# CITY OF ALBUQUERQUE

February 19, 2020

**Re: Monterey Place Apartments – 2306 Central Ave SW  
Erosion Sediment Control Plan  
Engineer's Stamp Date 2/12/20 (J12E030)**

EROSION CONTROL PLAN - MONTEREY PLACE APARTMENTS

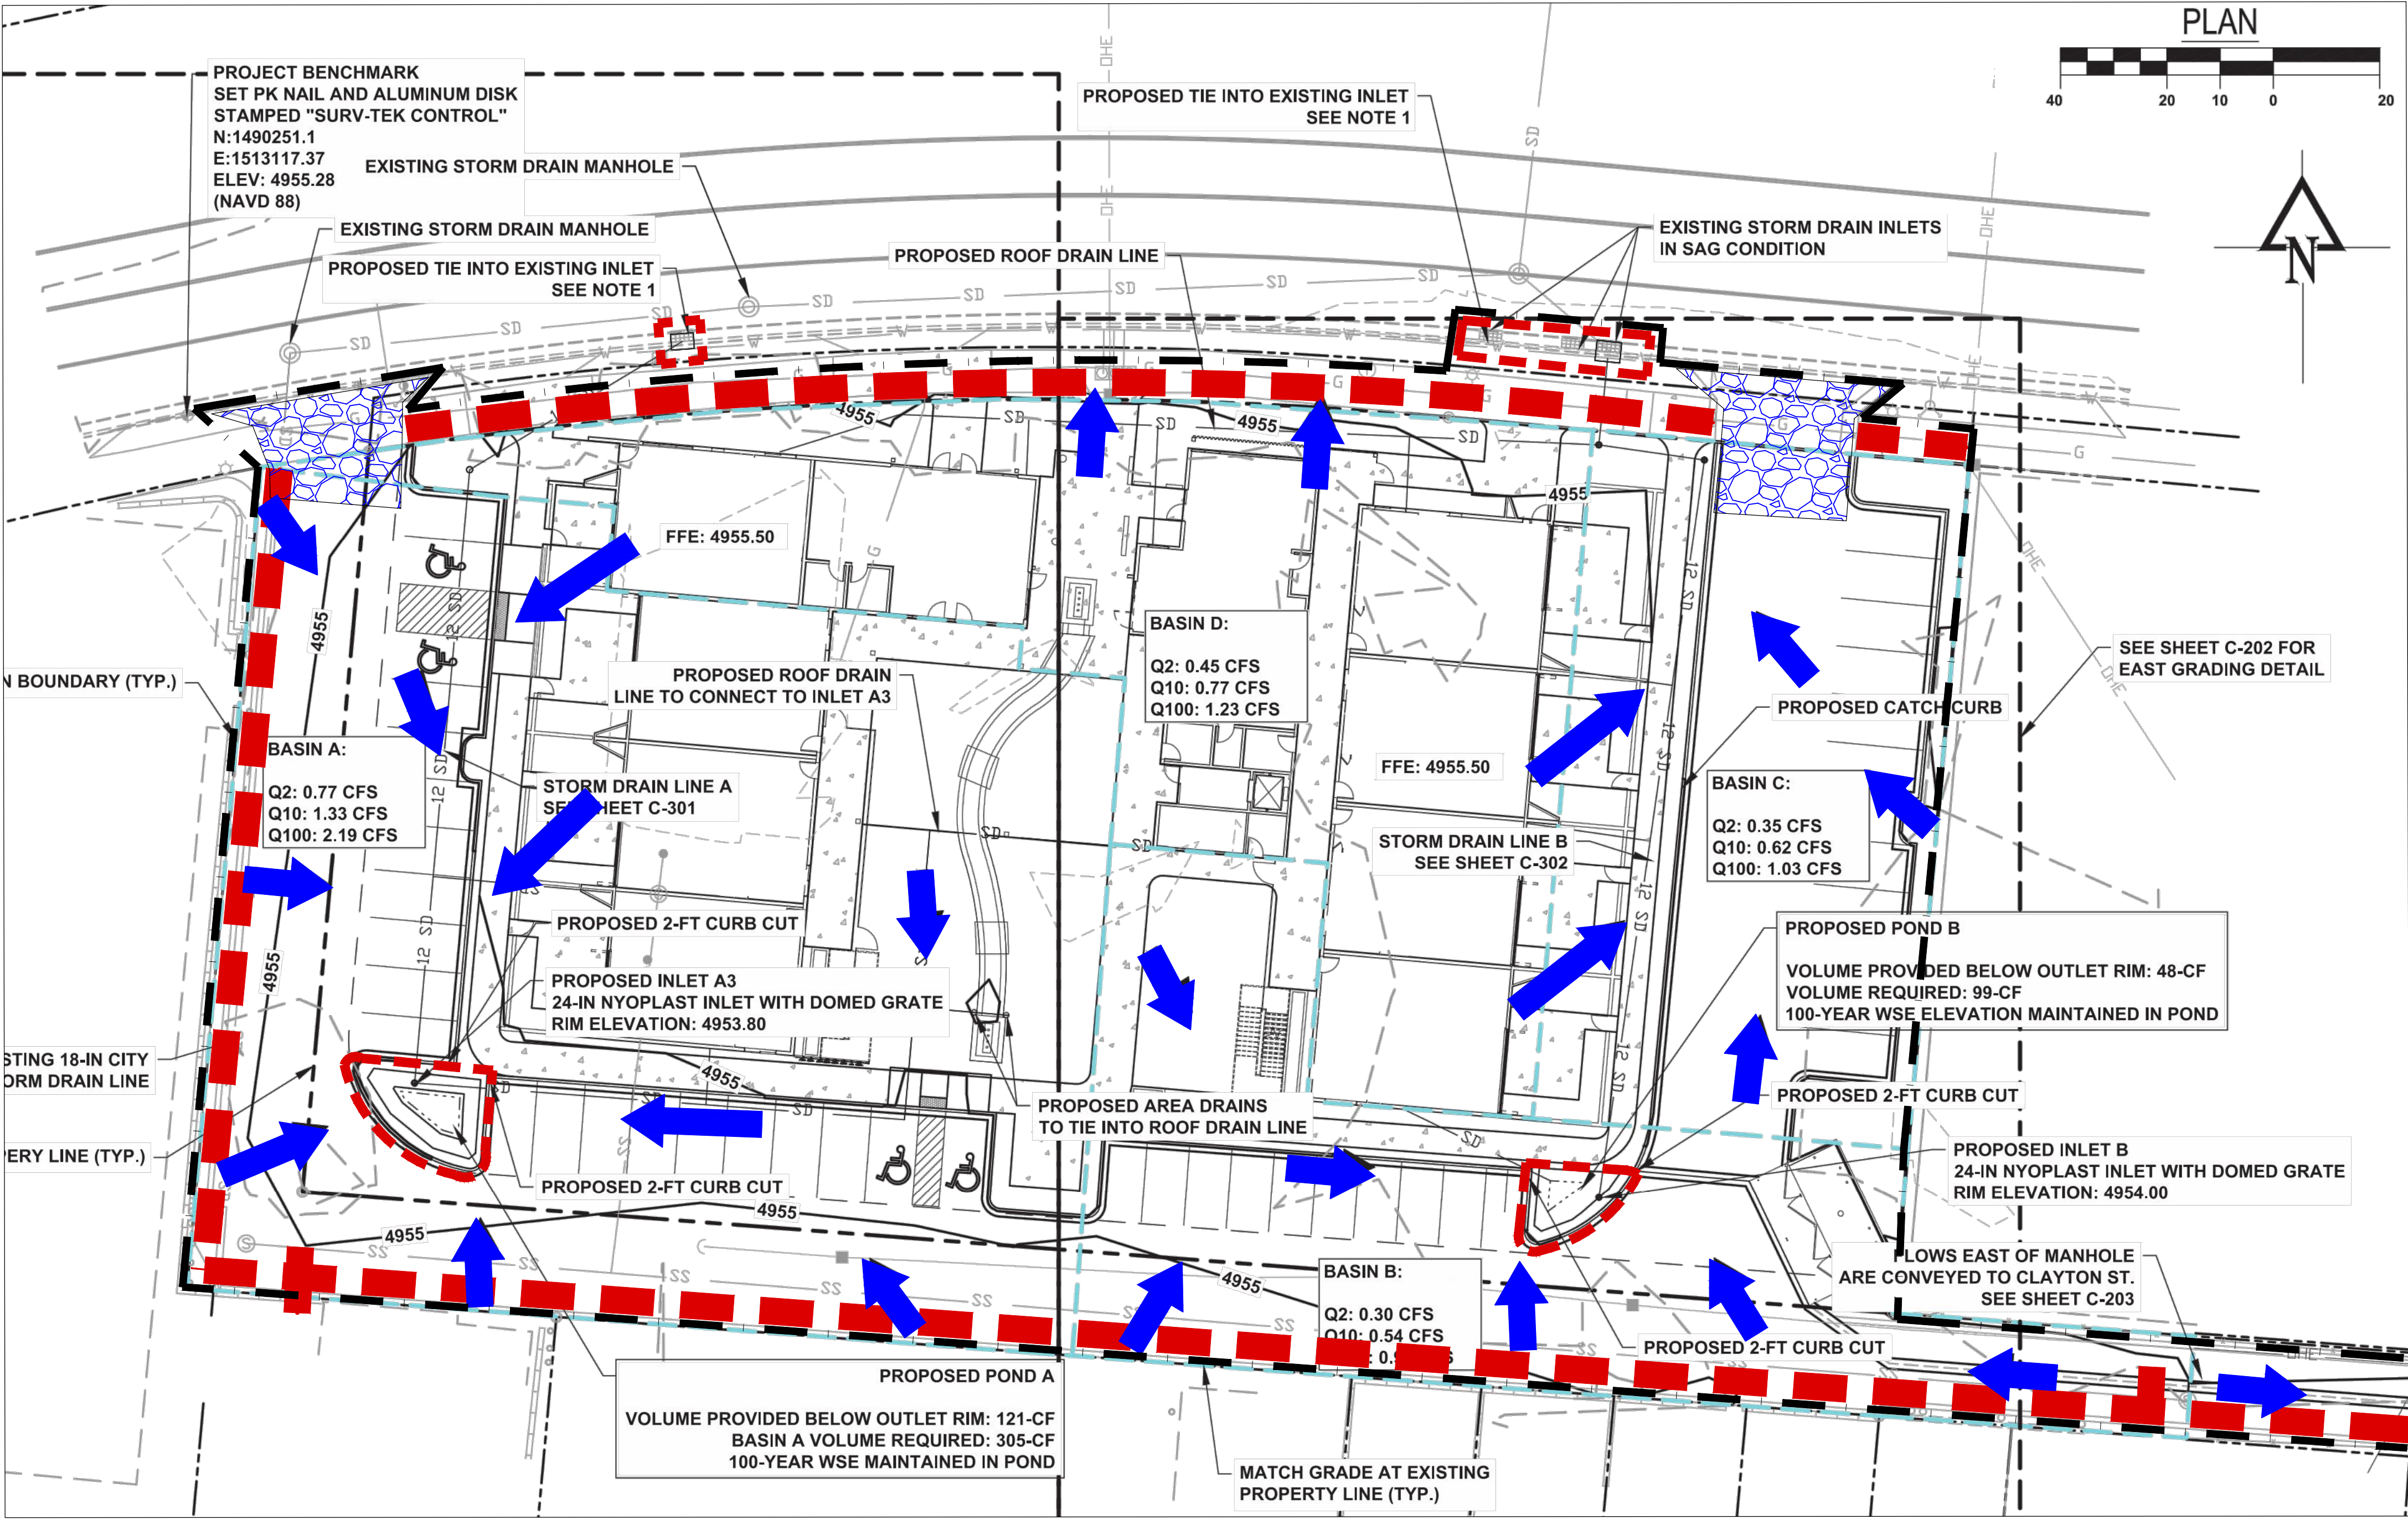
1. The wording of Erosion Control Note # 3 is inconsistent with the criteria in CGP 2.2.14.b. and should be deleted. The 70% criteria refers only to the portion of the site not covered by structures, and further refers to the minimum density of permanent vegetation where only vegetation is used. It also says there should not be any large bare areas. City standard notes 3 and 4 address the issue of final stabilization (see below).
2. Adjust the Limits of Disturbance to include the removal of the two driveways on Central that will not be used and that must be removed by the Work Order. Also allow for the storm drain connections to the existing inlet on the west side of the site.
